Application Ref:	2025/0869			 Ribble Valley Borough Council www.ribblevalley.gov.uk
Date Inspected:	N/A	Site Notice:	N/A	
Officer:	SK			
DELEGATED ITEM FILE REPORT:				APPROVAL

Development Description:	Proposed residential development of a detached dwelling.
Site Address/Location:	Land opposite Ashbrook Ribblesdale Avenue Clitheroe BB7 2HZ

project	project number	drawing number
ribblesdale avenue	25.42	PL.03
name	proposed site and roof plan	
scale	date	status
1 to 100 @ A1	october 2025	planning
revision	A

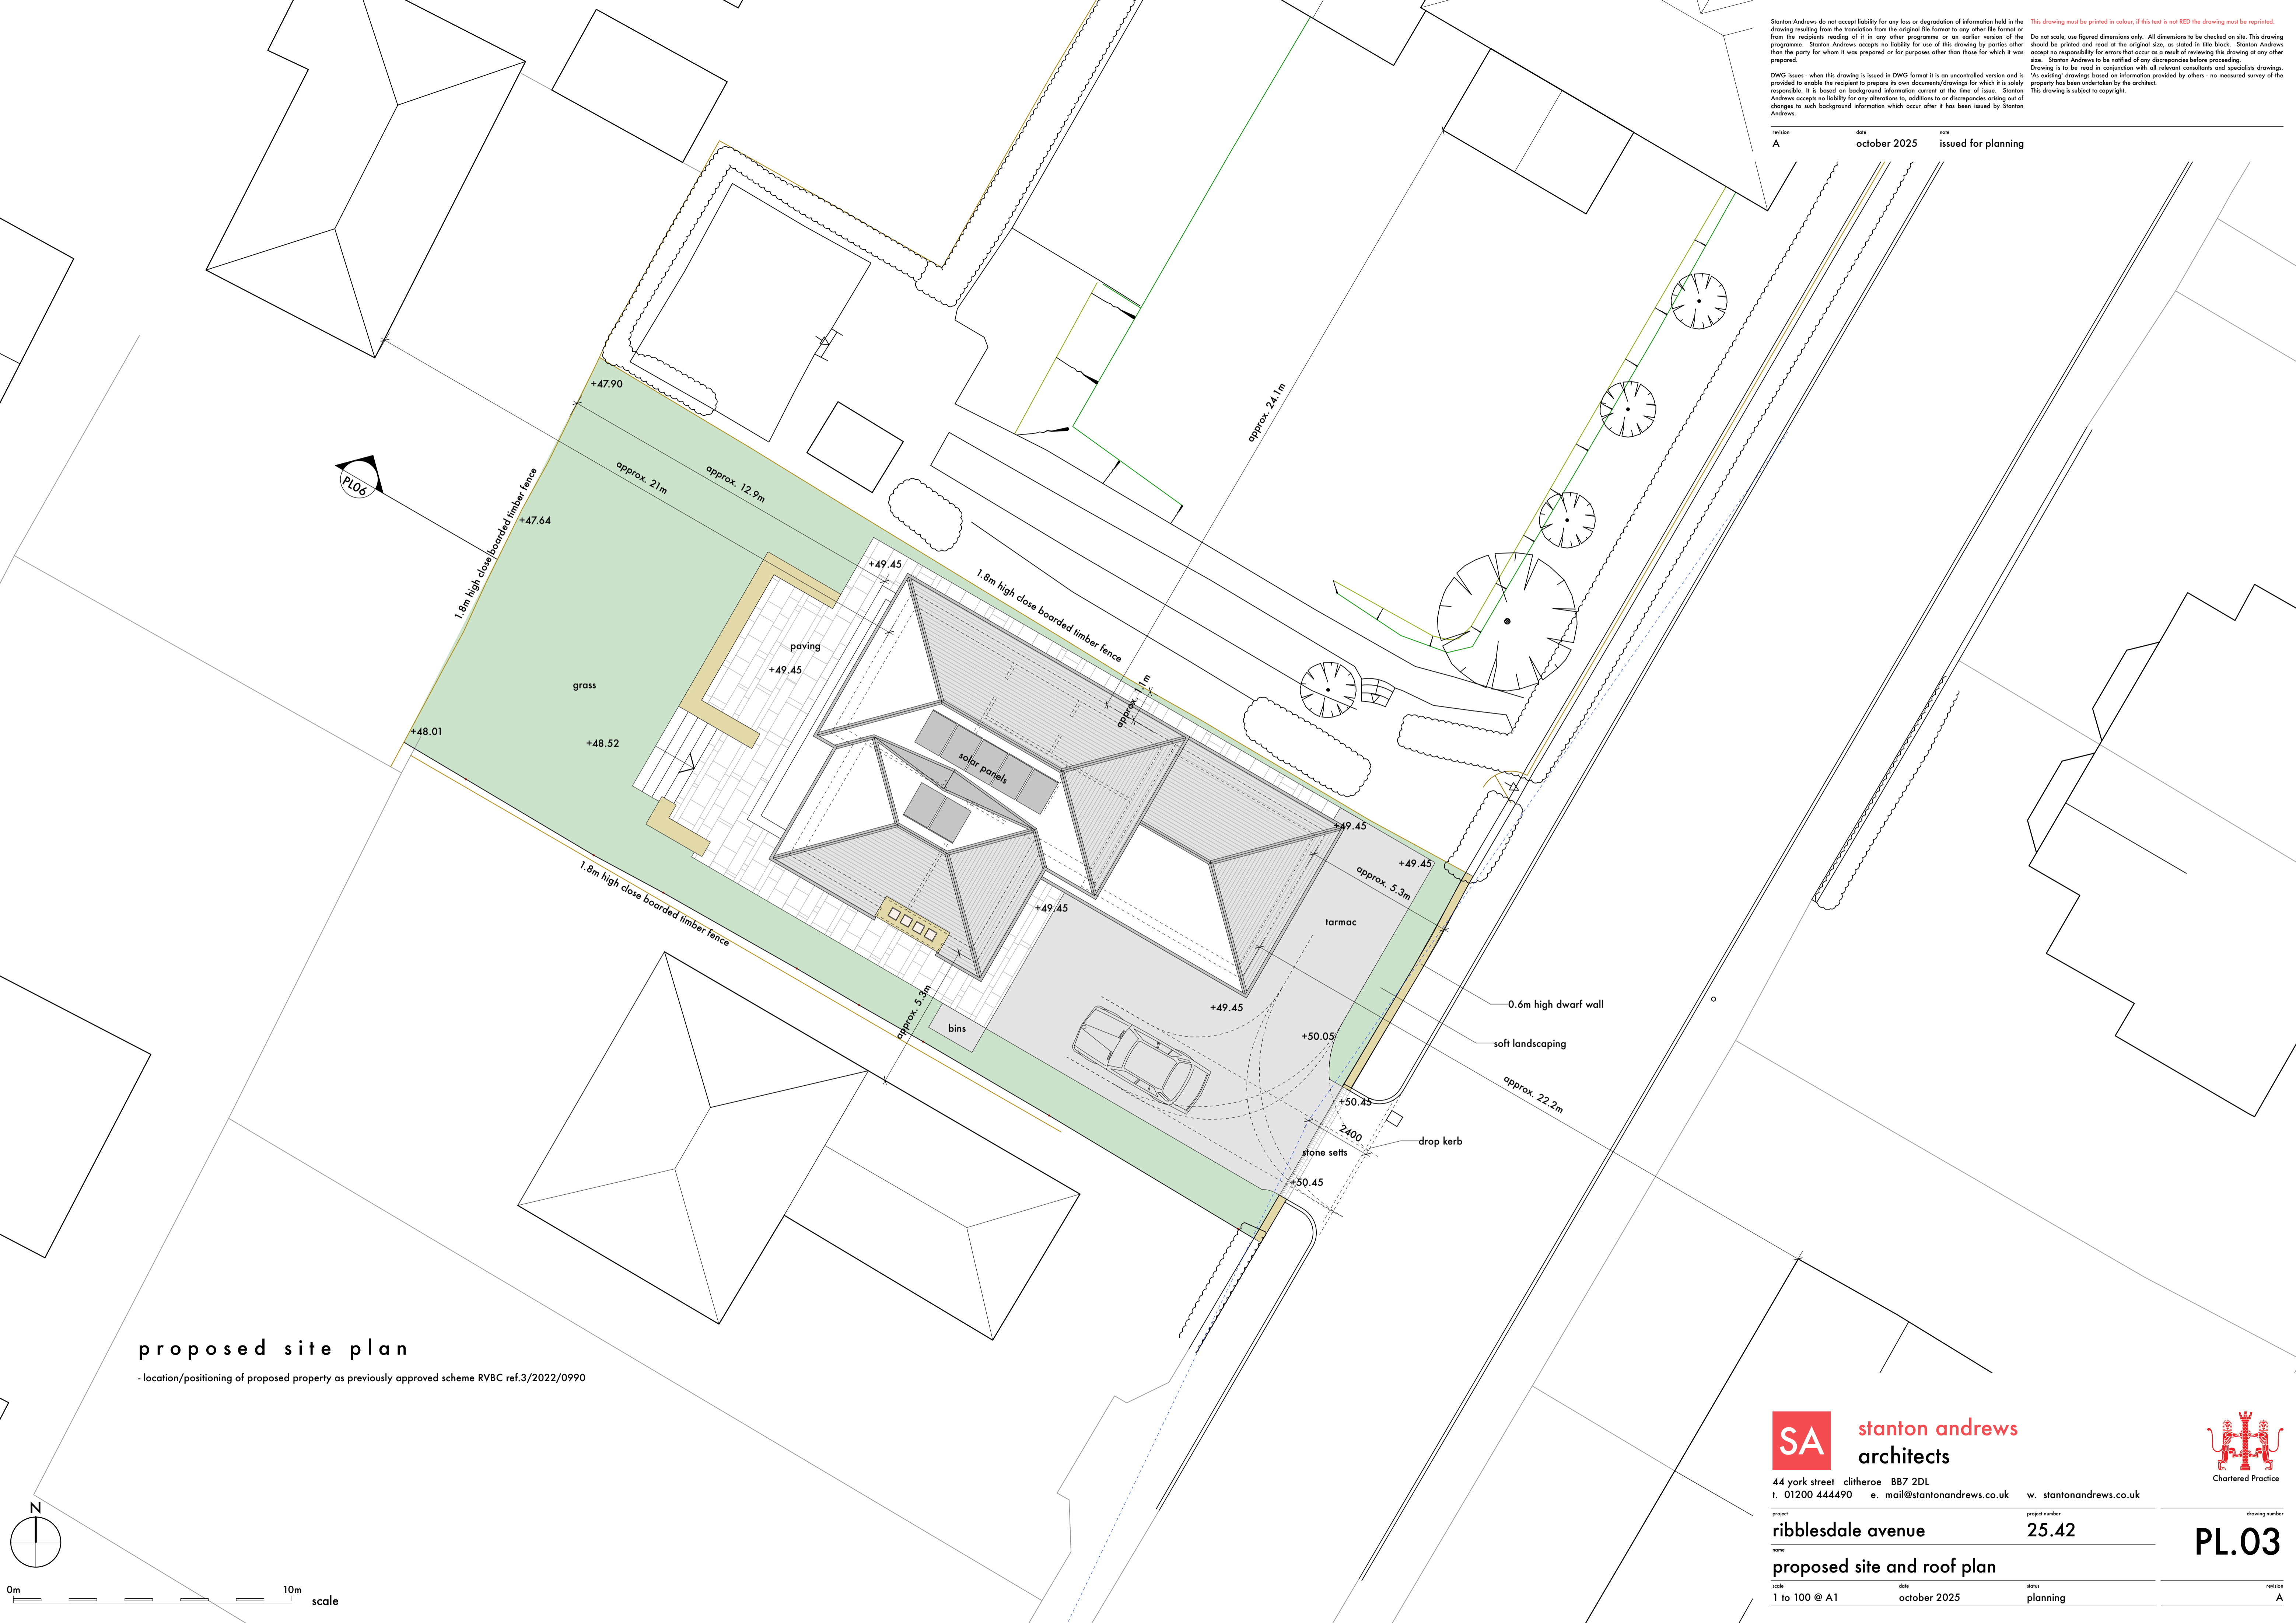
Site Access The LHA have reviewed drawing number PL.03 Rev A titled Proposed Site and Roof Plan and are aware that the proposed access is similar to the previously approved scheme under planning application 3/2022/0990. The site will be accessed from a new access onto Ribblesdale Avenue, which is

an unclassified road, subject to a 20mph speed limit. The width of the proposed access complies with the LHAs guidance and to ensure adequate intervisibility between highway users at a new access a visibility splay set 2.4 metres back from the near edge of the carriageway and extending 25 metres along the nearside carriageway edge in both directions should be provided. (The site line requirement is based on table 7.1 from Manual for Streets).

The visibility splay should be wholly within the land which the applicant controls and/or the adopted highway and nothing shall be erected, retained, planted and / or allowed to grow at or above a height of 0.9 metres above the nearside carriageway level which would obstruct the visibility splay of the proposed access.

The applicant has provided a visibility splay drawn within the site plan which shows that acceptable visibility can be achieved in the North/East direction. The visibility splay drawn in the opposite direction, South/West, is approximately 20m long, however given the straight nature of Ribblesdale Avenue it is likely that the additional 5m can be achieved.

The new site access will require the applicant to enter into a Section 278 agreement to create the access due to the presence of a gully located adjacent to the access, which may need to be relocated.

The recommended minimum internal dimensions for a single garage size is 6m in length and 3m wide. A double garage recommended internal dimensions is 6m in length and 6m wide. The recommended distance of 6m is based on the length of a large family car (Ford Mondeo Estate 4.58m long), clearance at the rear of the car (200mm), overhang of the garage door (600mm) and room to stand in front of the car and open/close the garage door (600mm). As the proposed garage is smaller than the recommended minimum internal dimension of 6m in length, it should not be counted as a parking space.

A 3-bedroom dwelling should have 2 off street parking spaces to comply with the LHAs parking standards as defined in the Joint Lancashire Structure Plan. These spaces should measure 2.4m x 5m, where they are adjacent to a fence or similar obstruction an additional width of 0.6m should be provided. Where the driveway is shared pedestrian access an additional 0.8m should be provided. The LHA has reviewed drawing number PL.03 Rev A titled Proposed Site and Roof Plan and are aware that the dwelling complies with the LHAs parking standards as defined in the Joint Lancashire Structure Plan, as 2 off-street parking spaces can be catered for within the proposed driveway.

4. *No part of the development hereby permitted shall be occupied until such time as the access arrangements shown on drawing number PL.03 Rev A have been implemented in full.*

5. *No part of the development hereby permitted shall be occupied until such time as vehicular visibility splays of 2 metres by 25 metres have been provided at the site access. These shall thereafter be permanently maintained with nothing within those splays higher than 1 metres above the level of the adjacent footway/verge/highway.*

6. *The development hereby permitted shall not be occupied until such time as the parking and turning facilities have been implemented in accordance with drawing number PL.03 Rev A. Thereafter the onsite parking provision shall be so maintained in perpetuity.*

project	project number	drawing number
ribblesdale avenue	25.42	PL.04
name		
proposed - plans and elevations		
scale	date	status
1 to 100 @ A1	october 2025	planning
		revision
		A

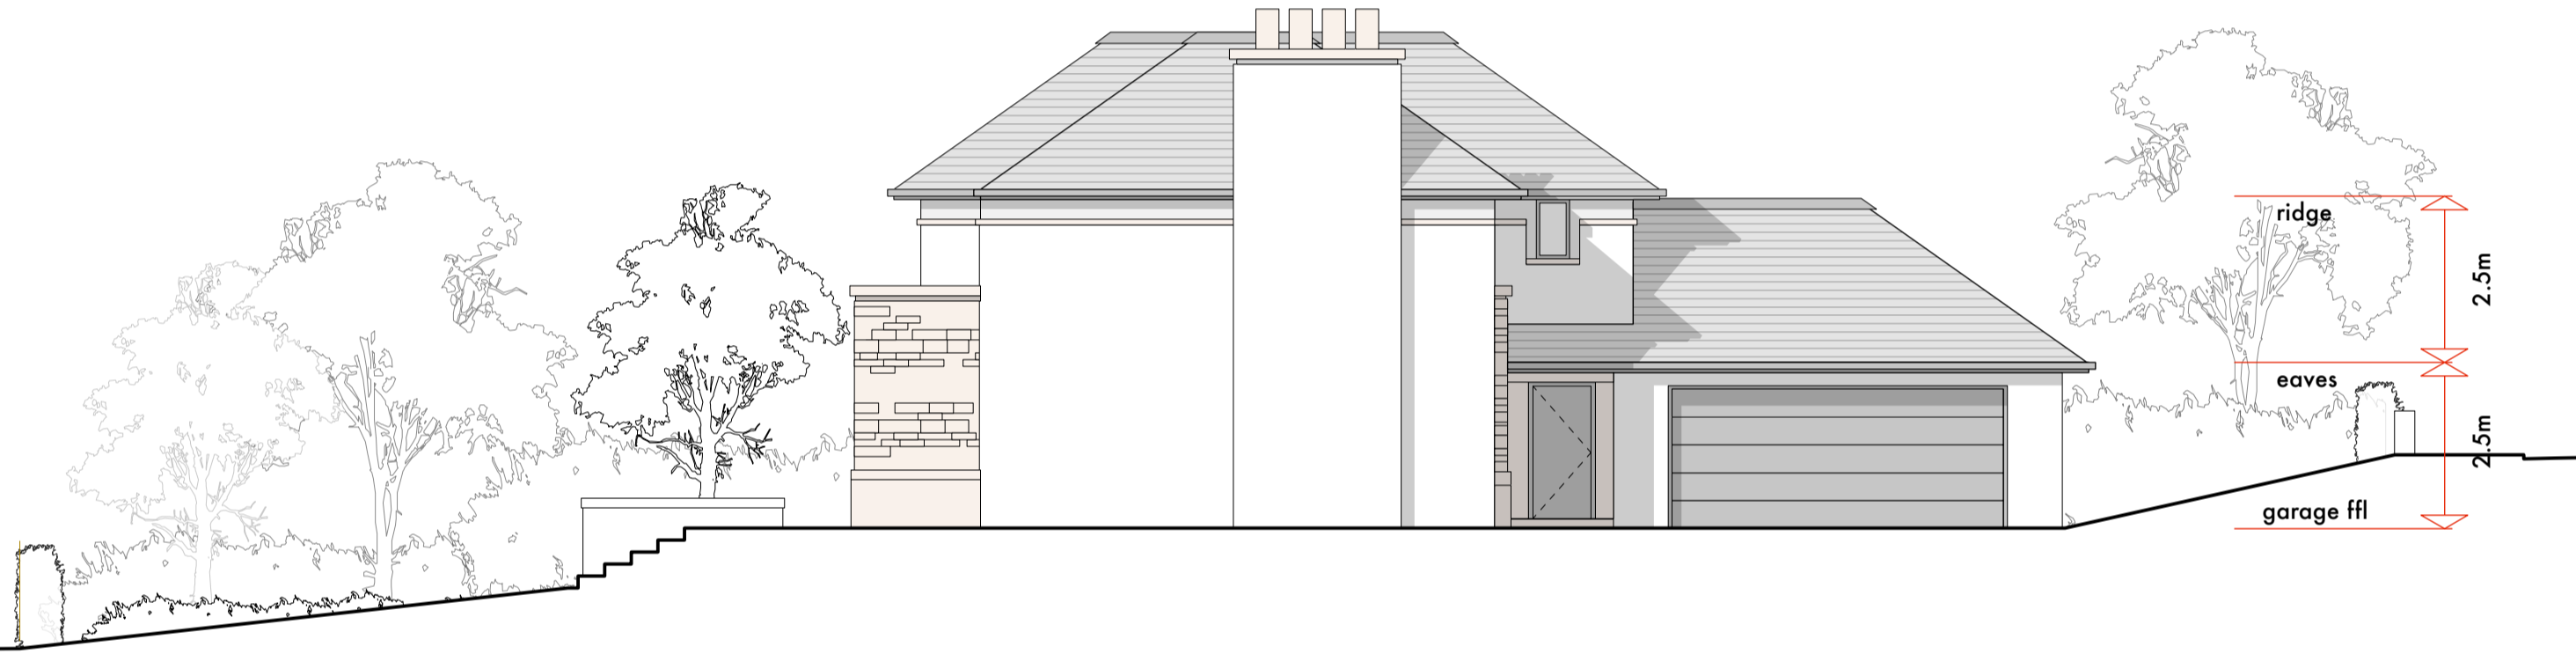
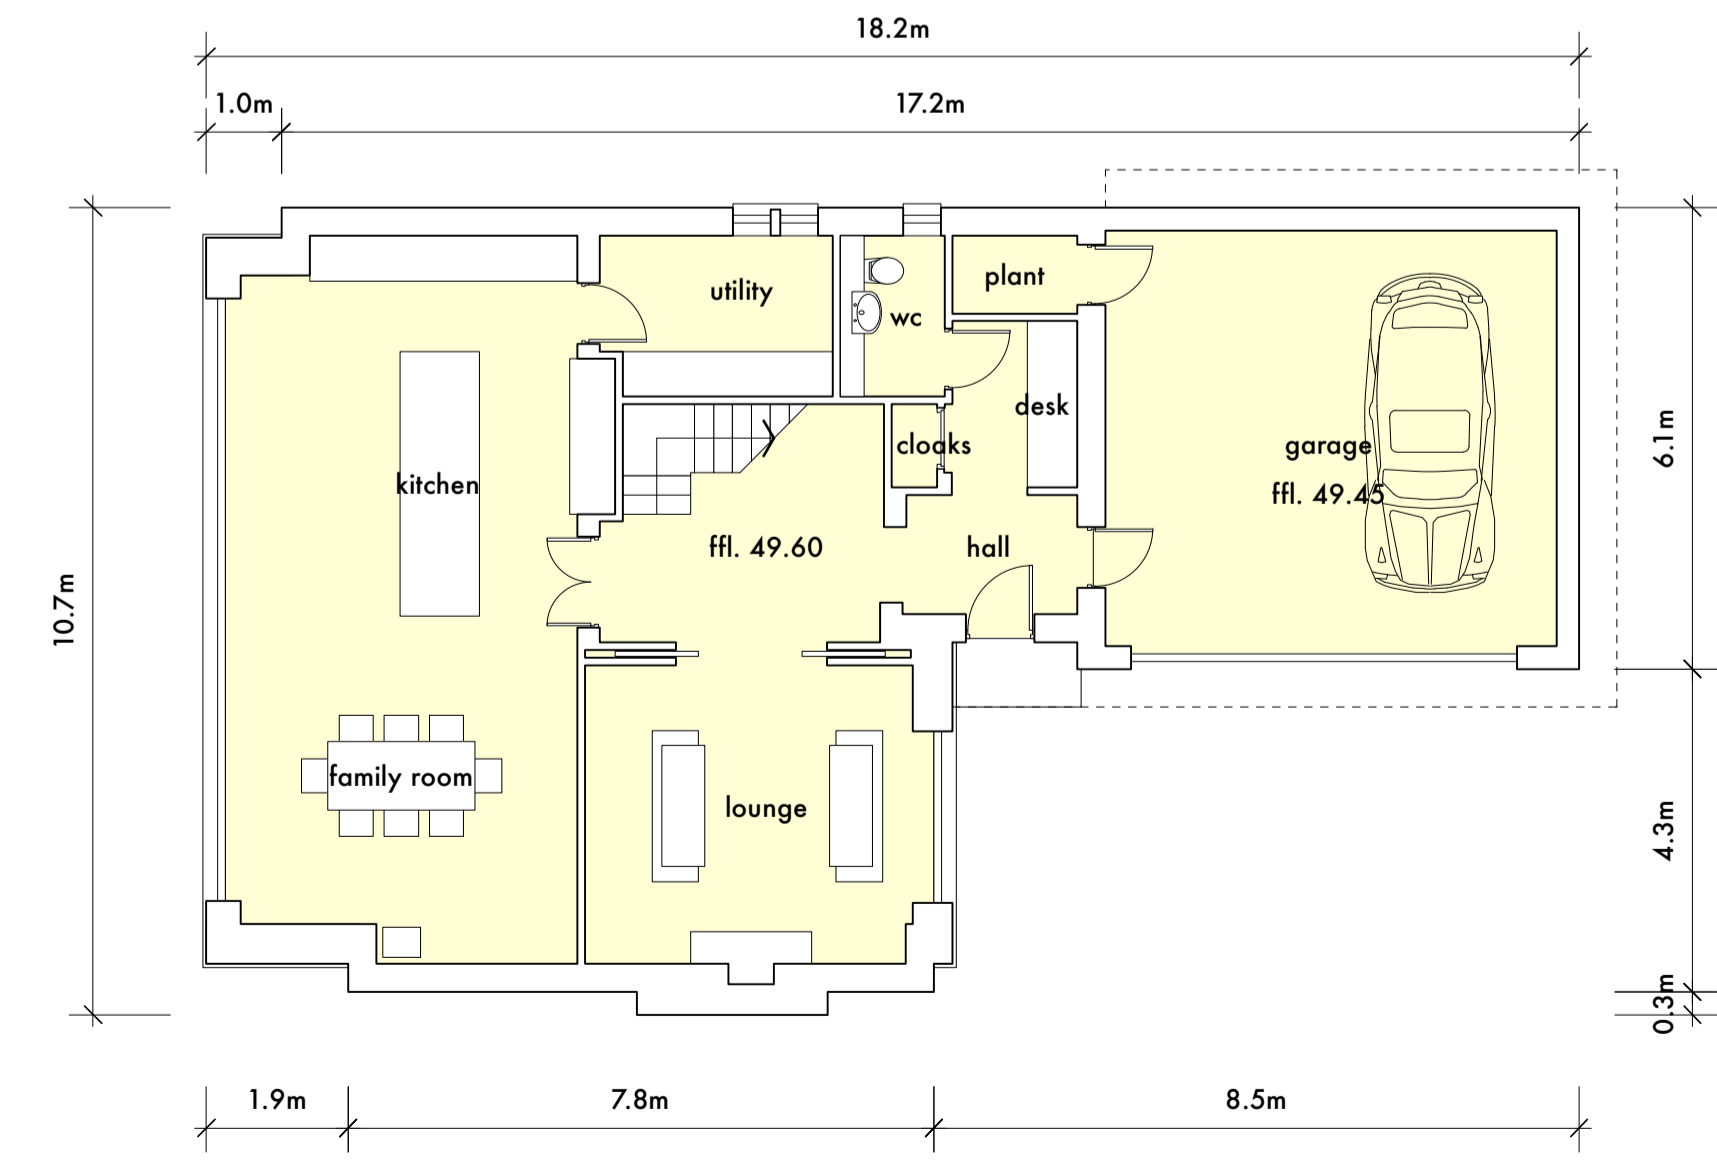
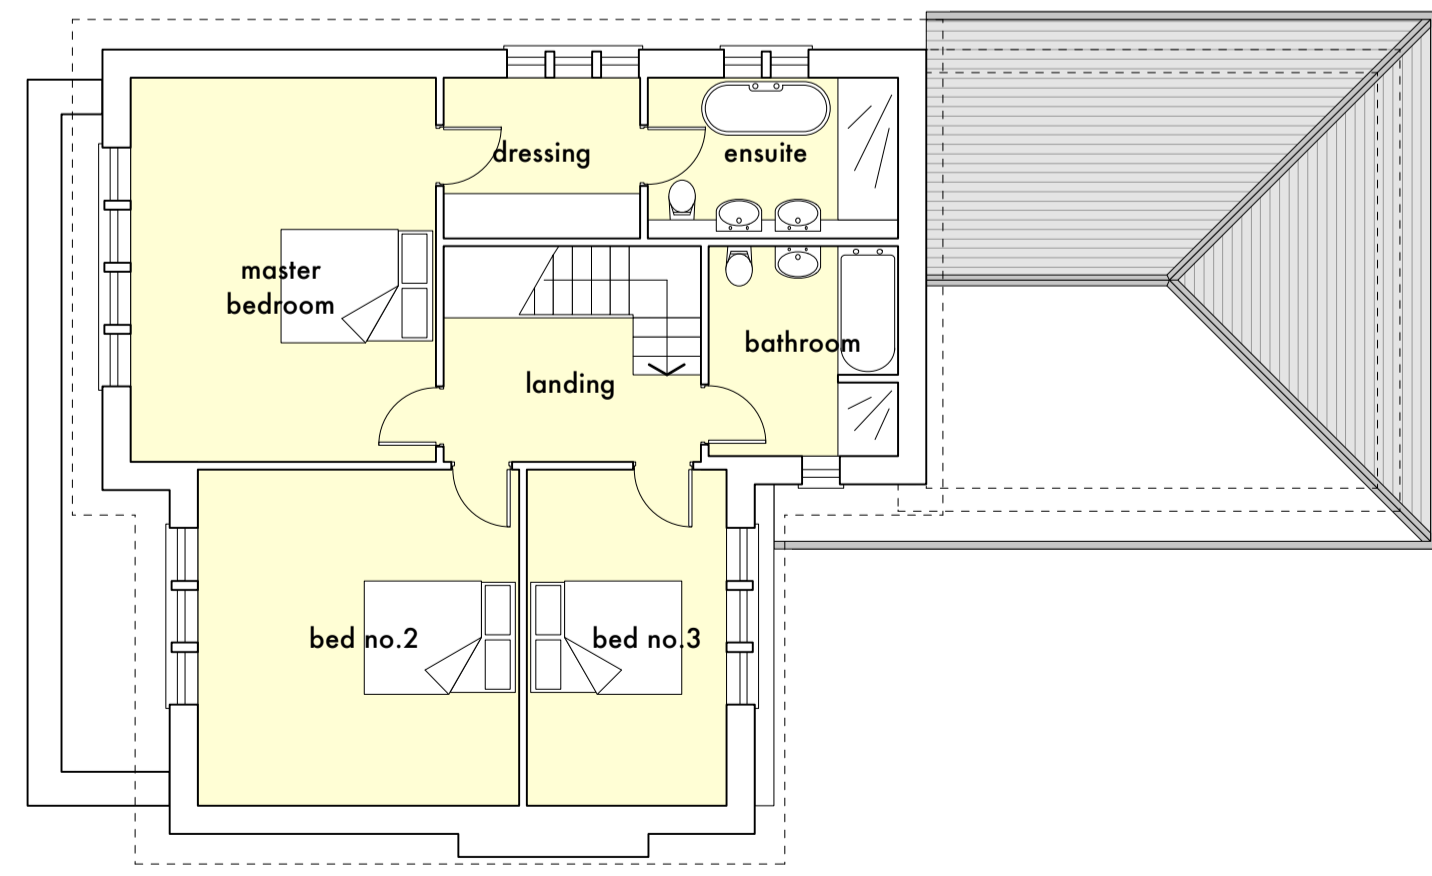
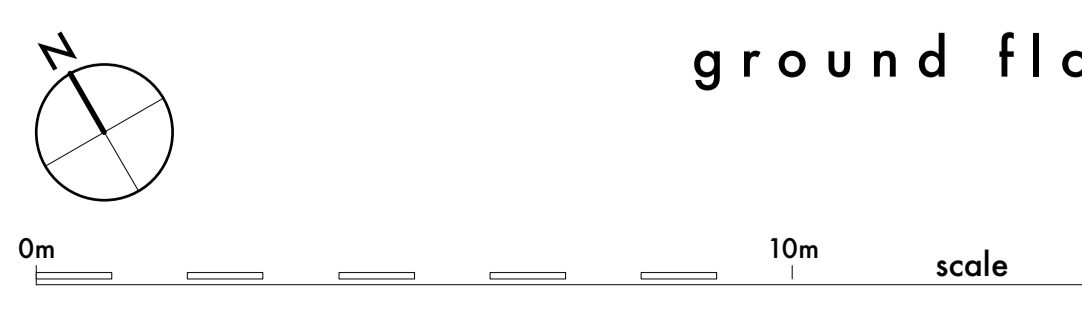
'The South-eastern elevation of the proposed dwelling would be sited in close proximity to the North-eastern elevation of Mulgrave house however the application's proposed site plan shows that a satisfactory separation distance would be in place between each of these elevations. In addition, the sole first floor window on the South-eastern elevation of the proposed dwelling would serve a bathroom and as such would be obscure glazed which in turn would prevent any potential occurrences of overlooking towards Mulgrave House.

The windows forming the North-western elevation of the dwelling would face towards the rear garden of No. 12 Dun Croft Close however this elevation of the proposed dwelling would be set back almost 13 metres from No. 12's boundary and as such would not compromise the privacy of the opposite neighbouring property.

Five first floor windows are proposed for the North-eastern elevation of the dwelling which would serve an en-suite and dressing room. These windows have the potential to provide unrestricted elevated views into the rear garden of Lingmoor therefore it is considered necessary to impose a condition to ensure that these windows remain obscure glazed in perpetuity in order to safeguard the privacy of the adjacent neighbouring property'
